ENG-SF22023-R3 GEC prelim redlines.pdf Markup Summary

Subject: Callout
Page Index: 1
Date: 4/10/2024 3:38:40 PM
Author: Jeff Rice - EPC Engineering Review
Color: ■
Layer:
Space:
Page Label: [1] 1 GRADING & EROSION CONTROL COVER SHEET

**GRADING & EROSION
CONTROL INTERIM PLAN**

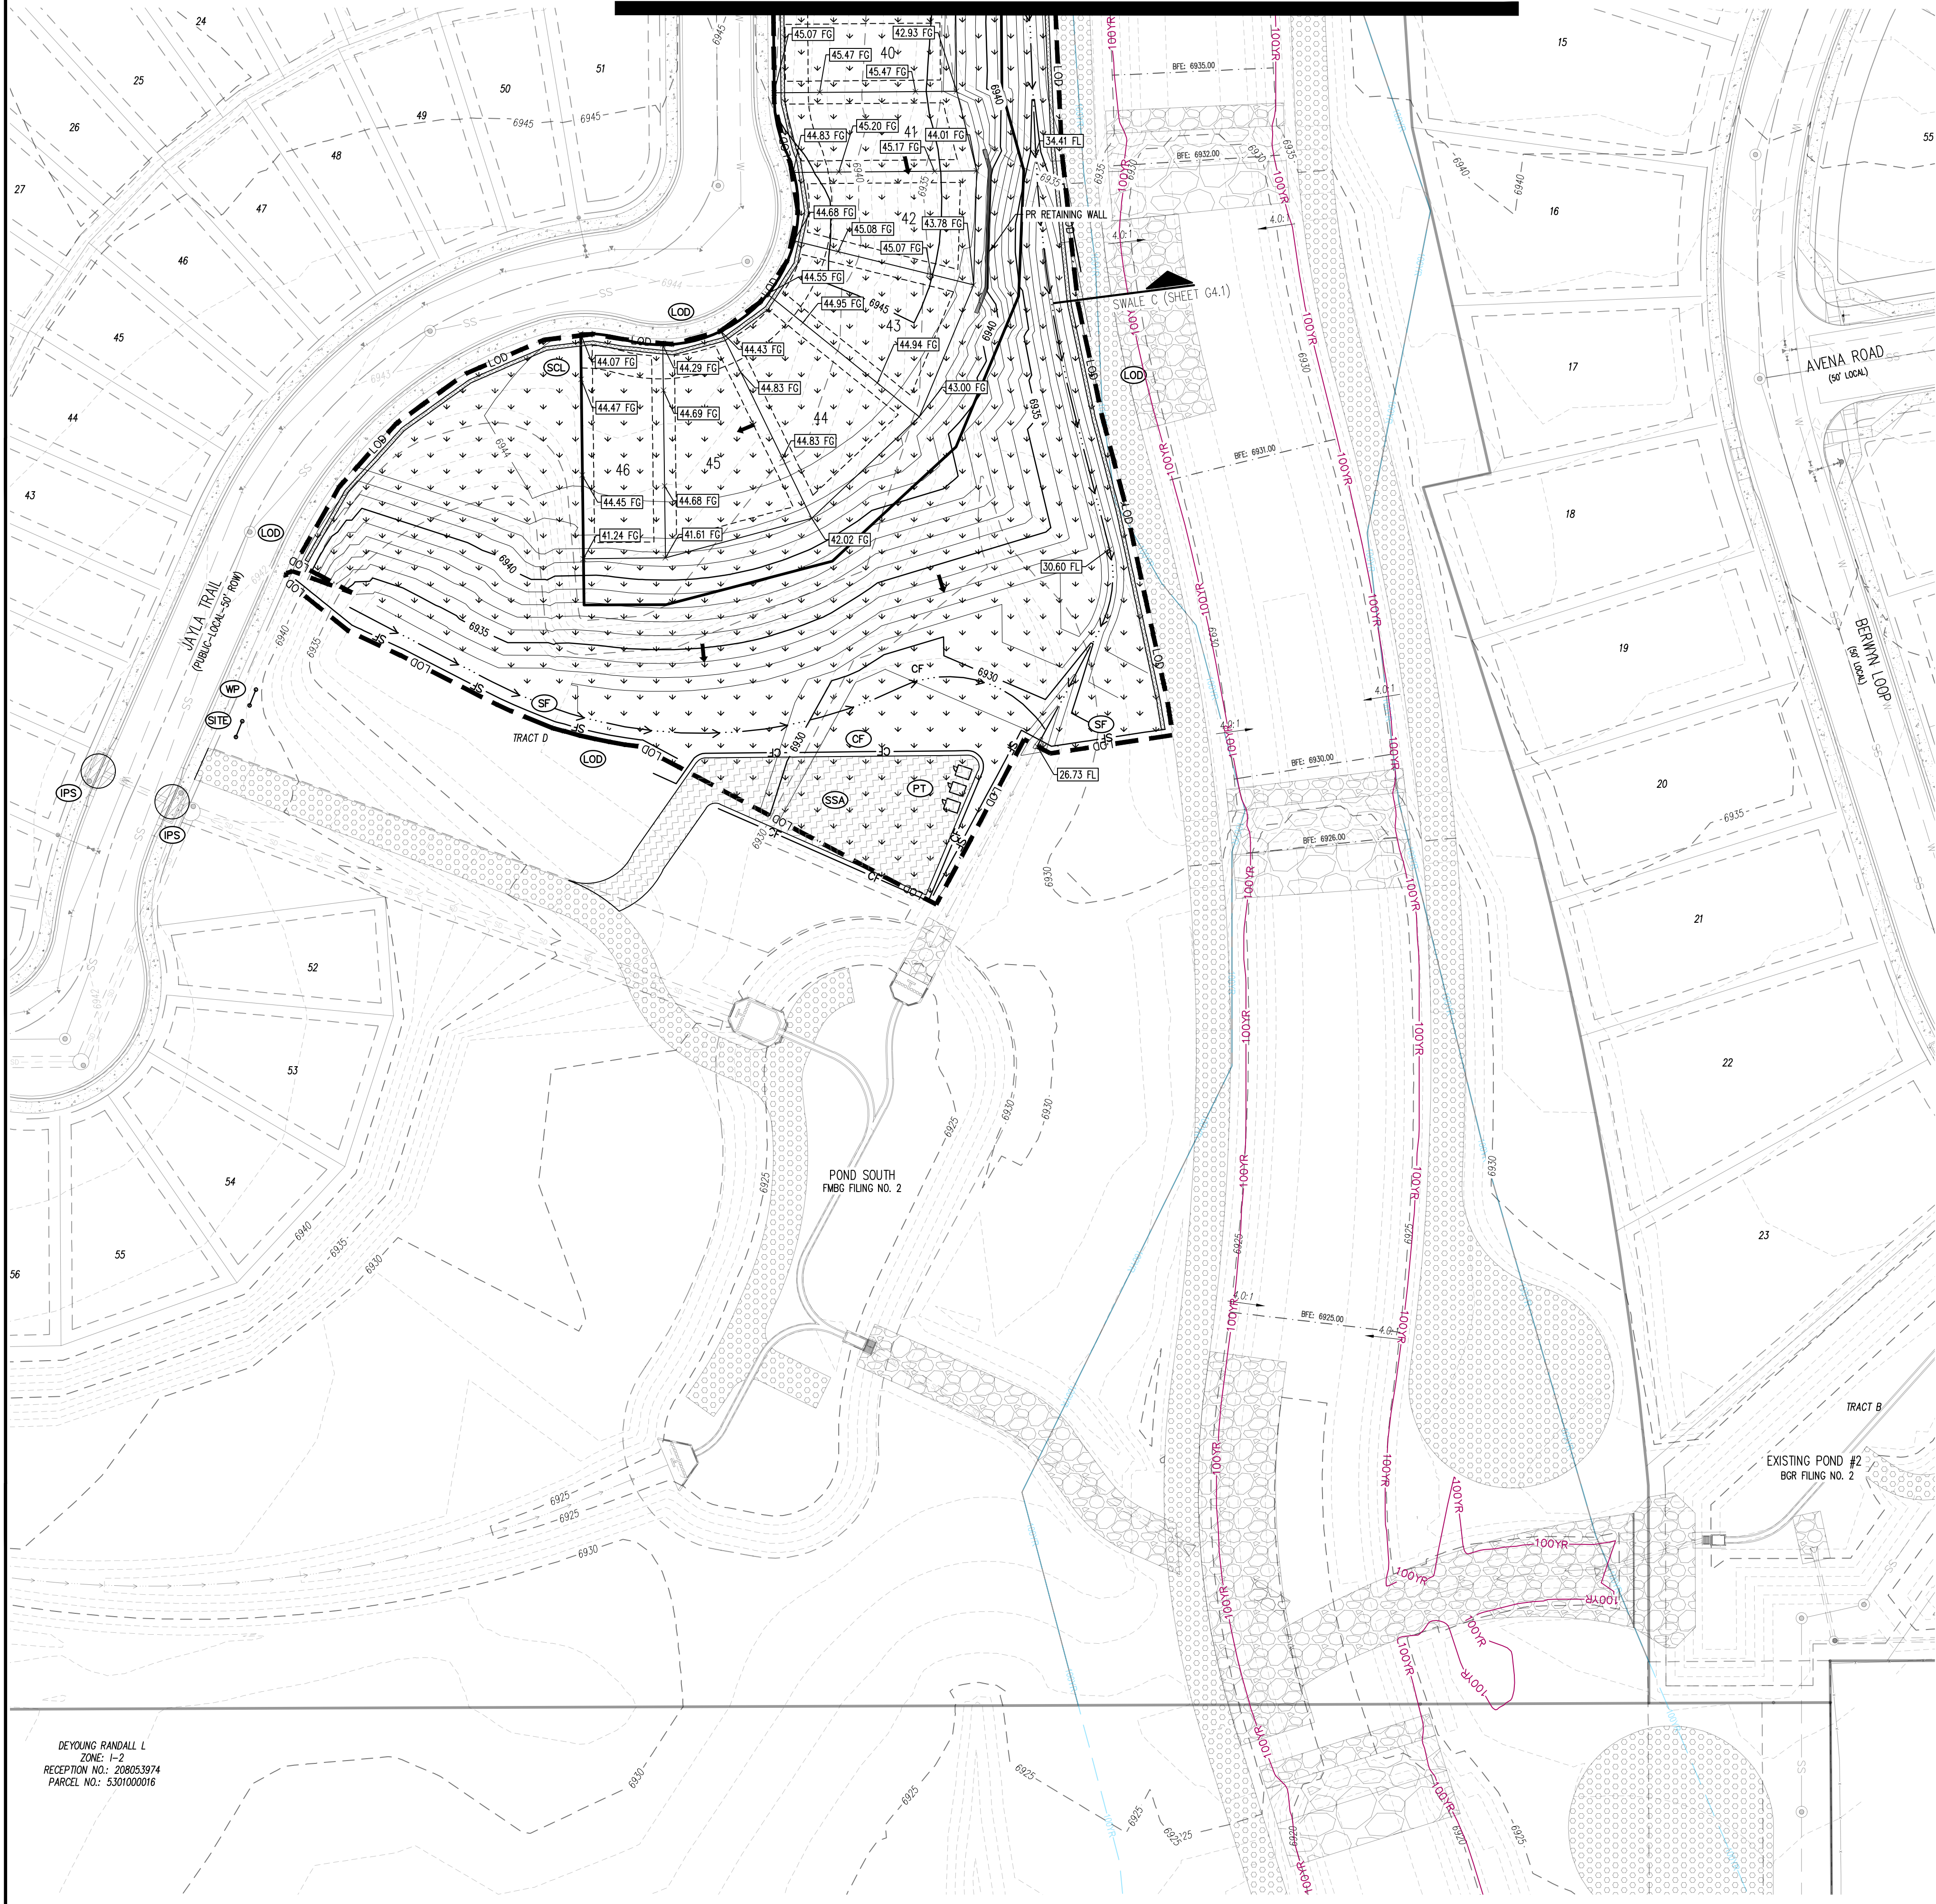
Label effective width of access road, provide cross-section at narrowest width.
